Subdivision Comments

From: Holly Erdman, B.S., Environmental Health Specialist II

RE: SP-23-00011 Barker

BARKER SHORT PLAT  
PART OF SECTION 6, T. 17 N., R. 20 E., W.M.  
KITITAS COUNTY, WASHINGTON

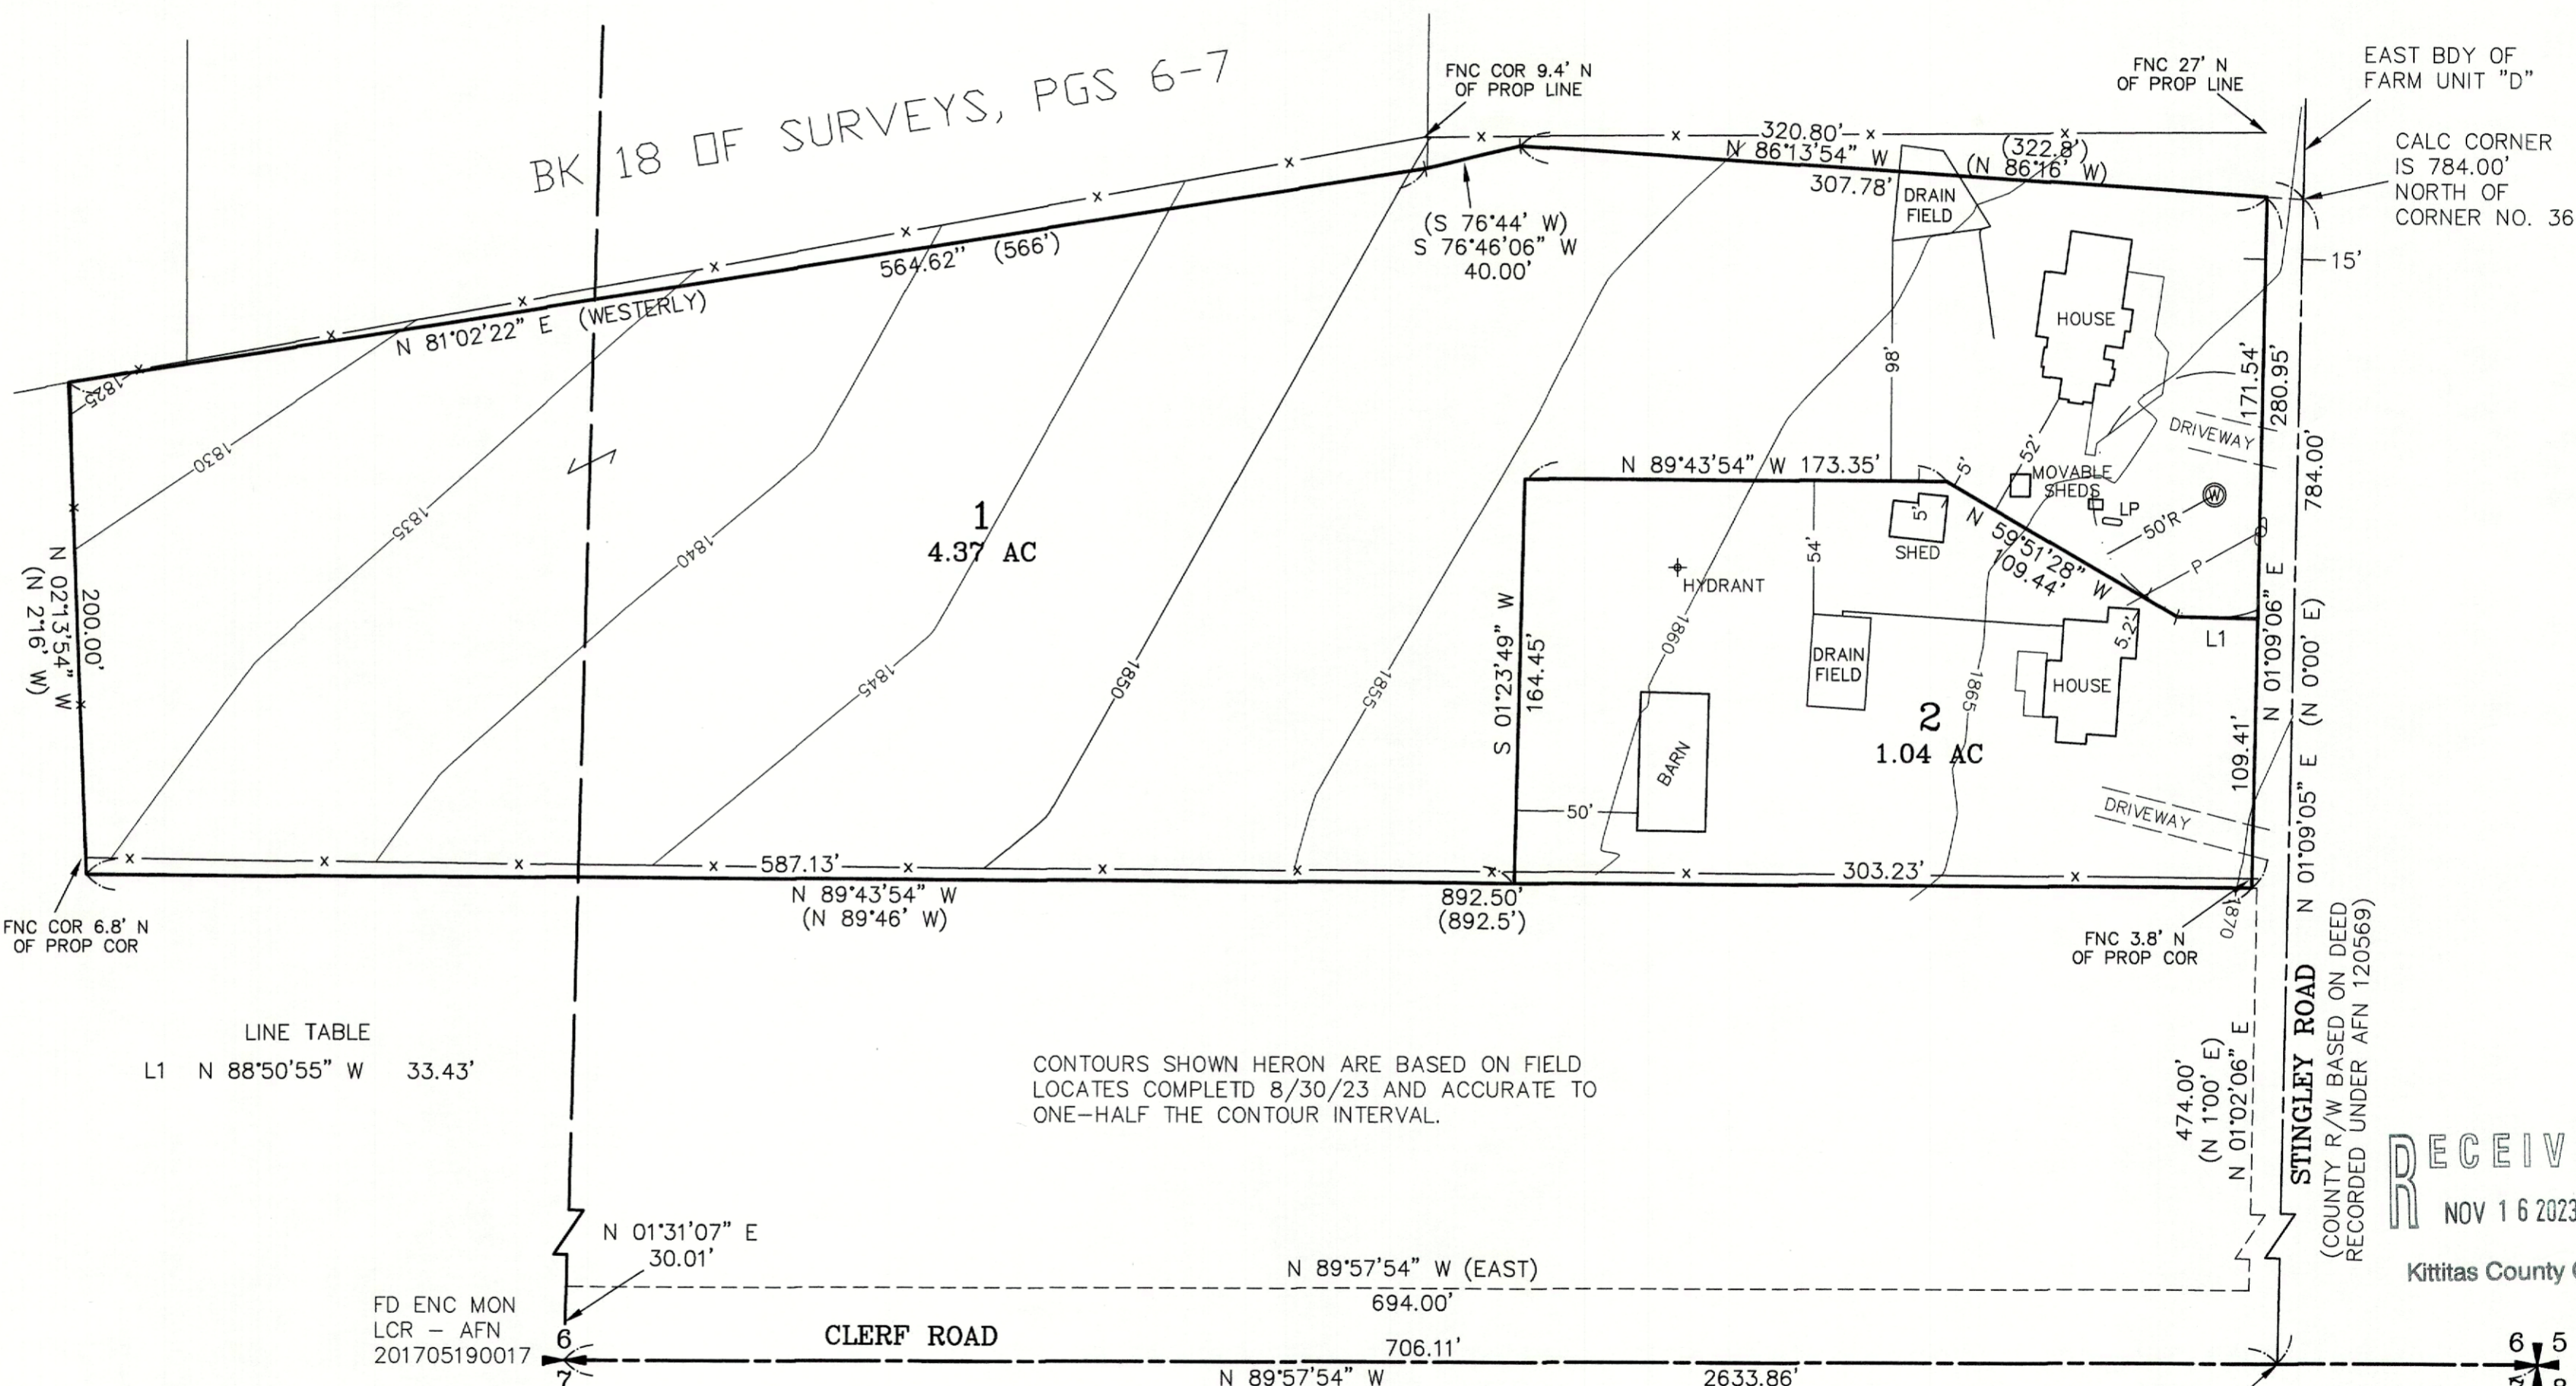
The proposed short plat drawing indicates there is an existing well on proposed lot 1. The applicant also indicates the existing well is a shared well.

A well log for the existing well on lot 1 must be submitted as well as a signed, notarized and filed shared water user's agreement must be submitted for review.
